URBAN DESIGN REVIEW PANEL REPORT

Project:	2213 – 1657 Carling Avenue	Date:	01 October 2024
Hearing Date:	07 September 2023	Pages:	48
Comments Received:	10 October 2023		
File No.	PC2024-0317 / D02-02-24-0032

RESPONSE TO UDRP RECOMMENDATIONS

Project:	2213 – 1657 Carling Avenue	Date:	16 October 2023
Hearing Date:	07 September 2023	Pages:	5
Comment Received:	10 October 2023

FLOOR PLAN LEVEL 11-28

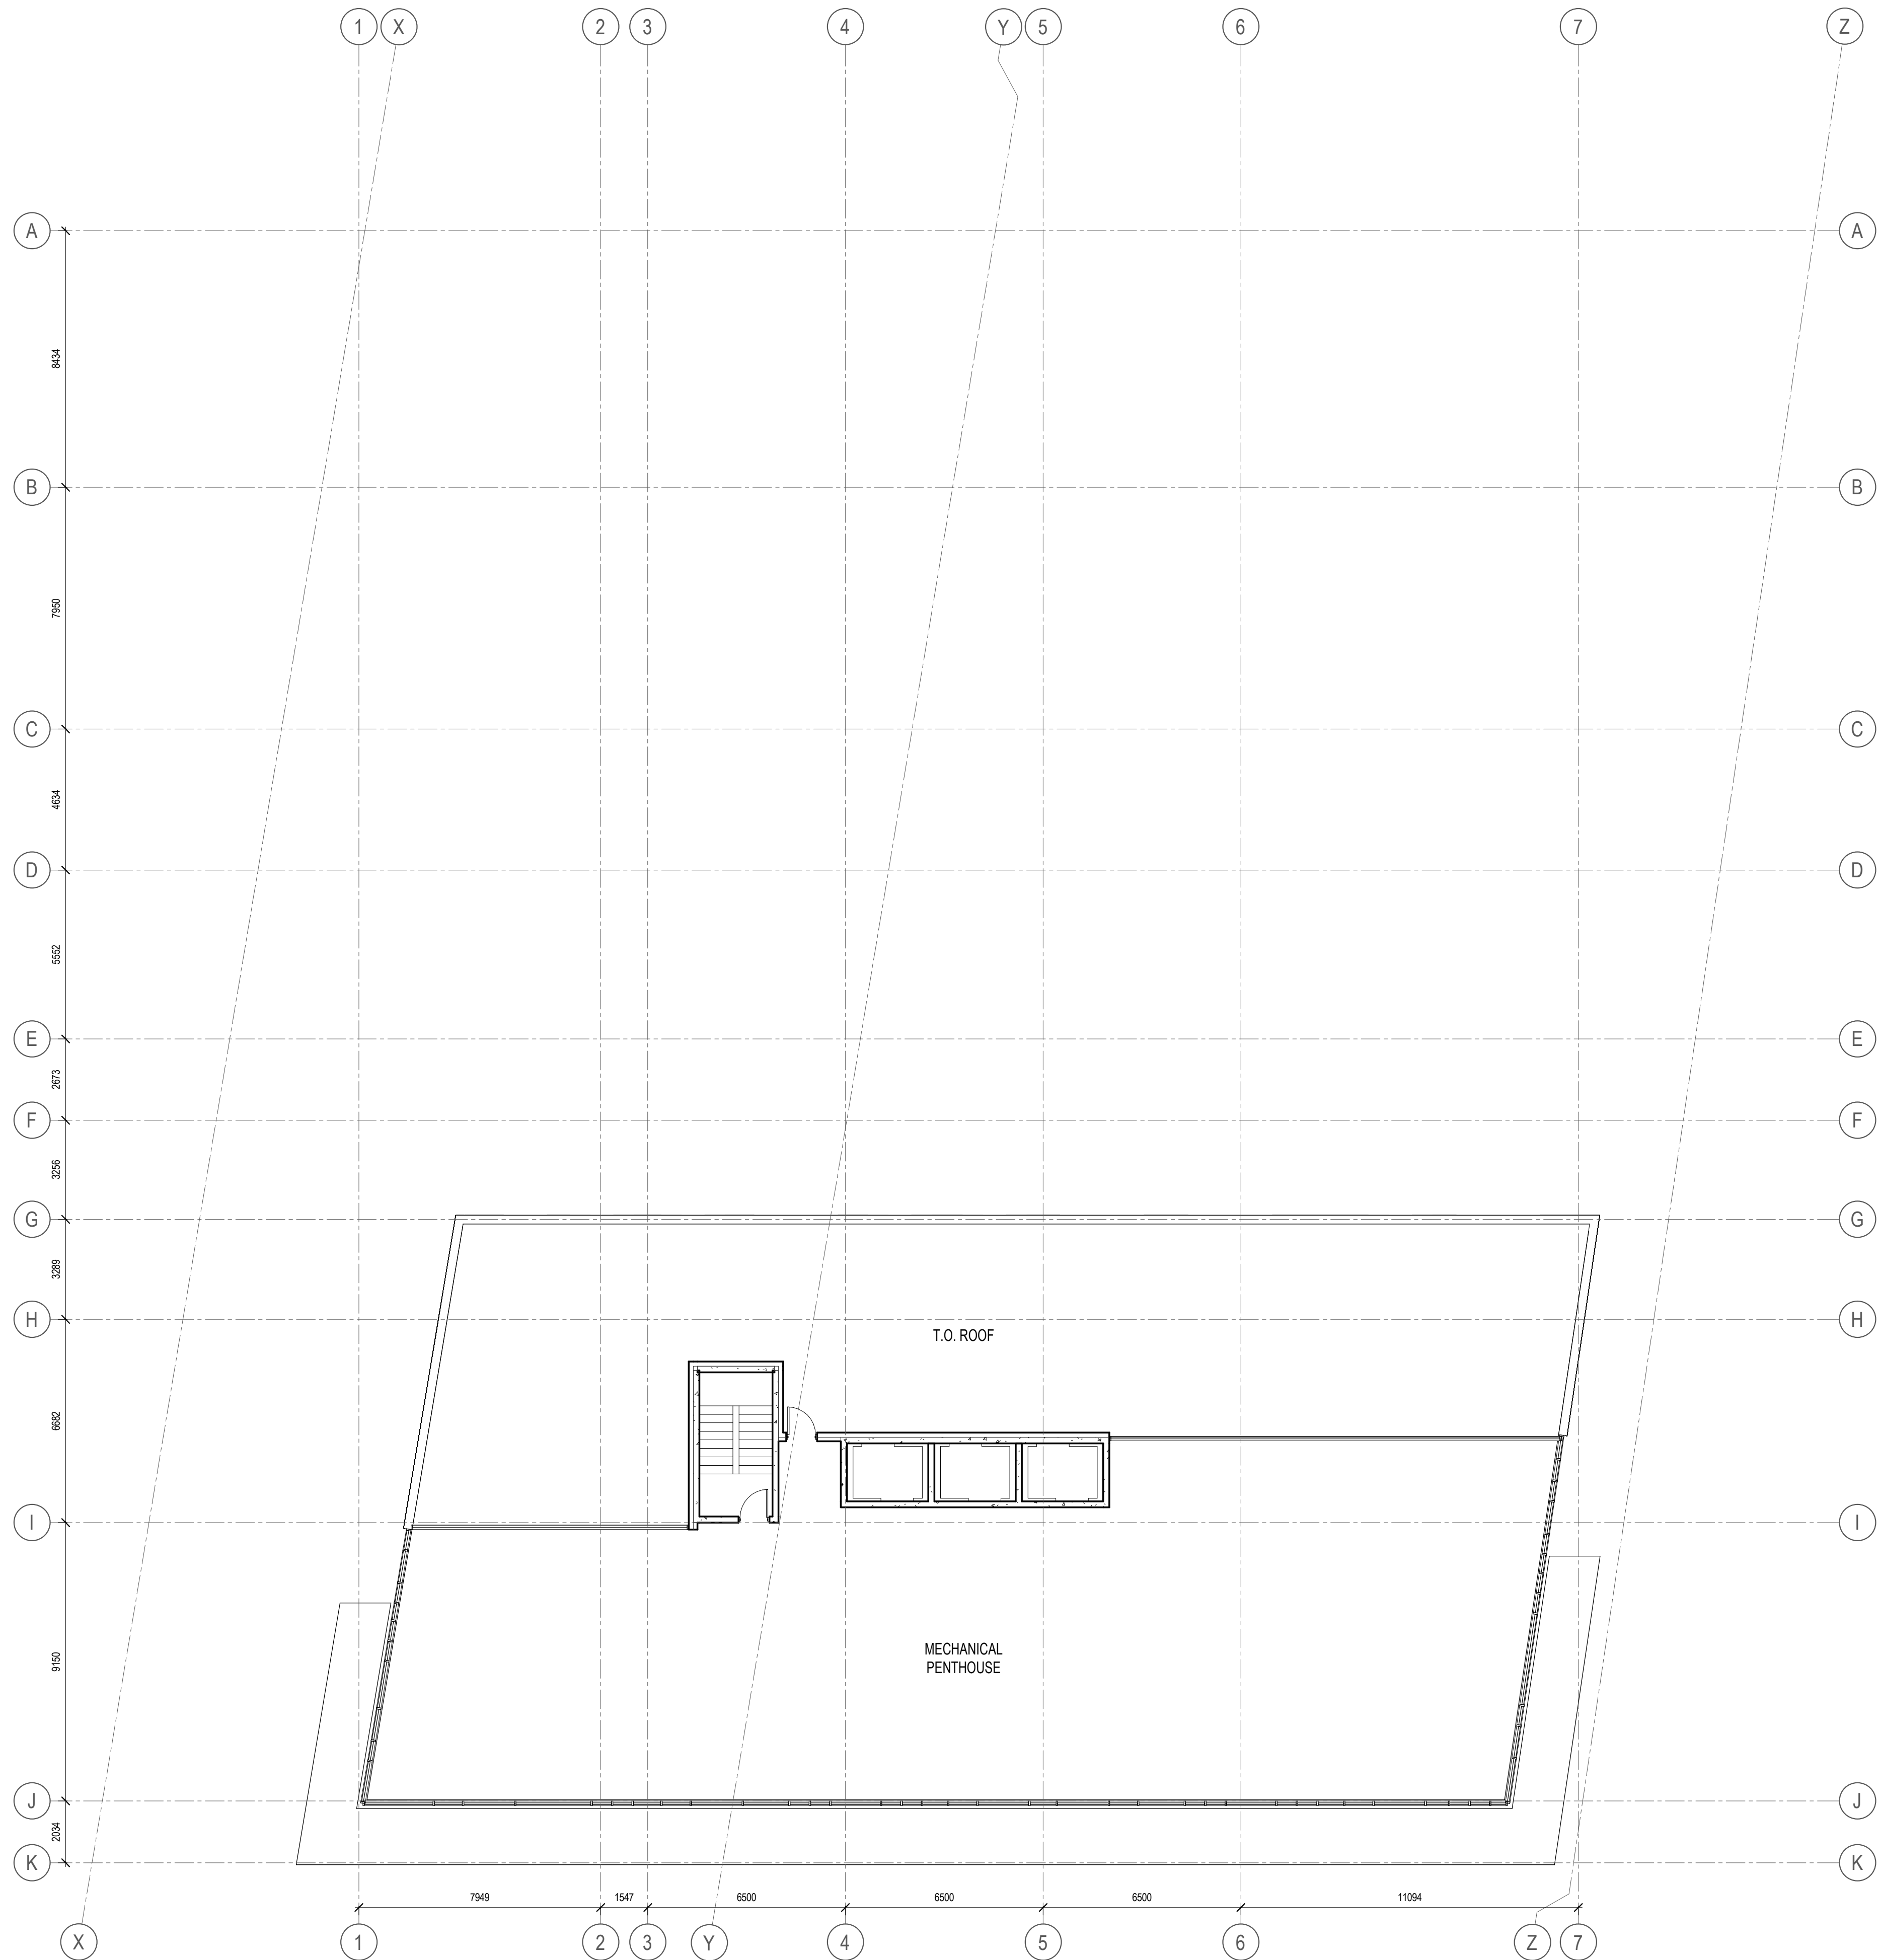
- *The Panel highly recommends the City's high-rise guideline of 750m² floorplates, inclusive of balconies, should be adhered to. As it stands, there is not a strong enough rationale for this project to be granted special consideration to this guideline.*
We understand that tall building guidelines are not standards but recommendations to be considered. We would question why a building that provides balconies would have a limitations on indoor space that a building without balconies would not face. Does this not encourage un-articulated buildings that are devoid of balconies? Is this the direction that is intended for high-rise buildings? I would also question why the 750m² floor plate includes balconies where the Toronto guidelines upon which Ottawa's were based does not.
